**Development Application and Planning Proposal Review
NSW Planning Portal Concurrence and Referral**

Authority	Authority's Reference	Agency Concurrence and Referral	Authority Contact	Authority Notification	Submission Due	Submission Made
NSW Dept. of Planning, Housing & Infrastructure	SSD-79500208		Patrick Copas	17/07/2025	18/08/2025	23/07/2025

Address	Land Title
Honeman Close, Huntingwood	Lot 1 DP 1098102

Environmental Impact Statement (EIS) for the Honeman Close Warehouse Facility. Construction and operation of two warehouse or distribution centres with ancillary office space and associated infrastructure and services (including intersection upgrade works on the Great Western Highway).

Figure 2: Proposed site and warehouse plan for Honeman Close Industrial Facility (Source: Goodman, January 2025)

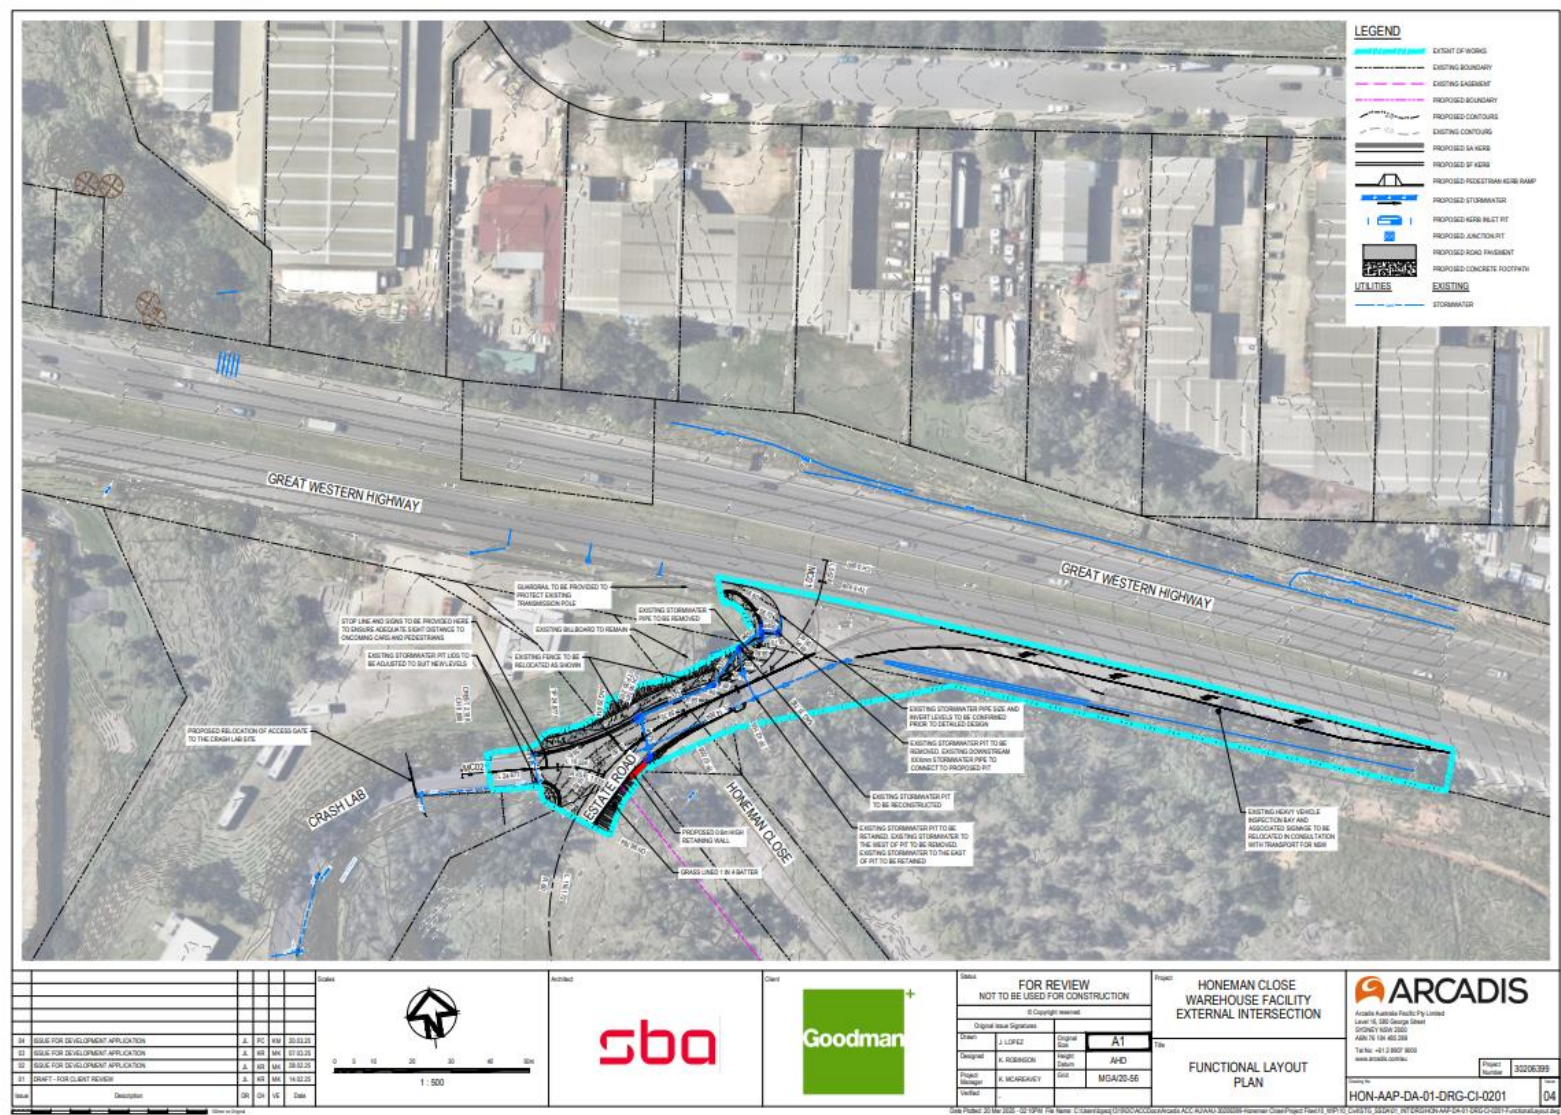
The below copy of the Site & Warehouse Plan does not appear to show provision for any padmount substations.

- Any required padmount substation/s will need to be located within the property (in a suitable and accessible location) and be protected (including any associated cabling not located within a public road / reserve) with an appropriate form of property tenure as detailed in the attached copy of Endeavour Energy's 'Land Interest Guidelines for Network Connection'.

Generally it is the Level 3 Accredited Service Provider's (ASP) responsibility (engaged by the developer) to make sure substation location and design complies with Endeavour Energy's standards the suitability of access, safety clearances, fire ratings, flooding etc. If the substation does not comply with Endeavour Energy's standards, the applicant must request a dispensation.
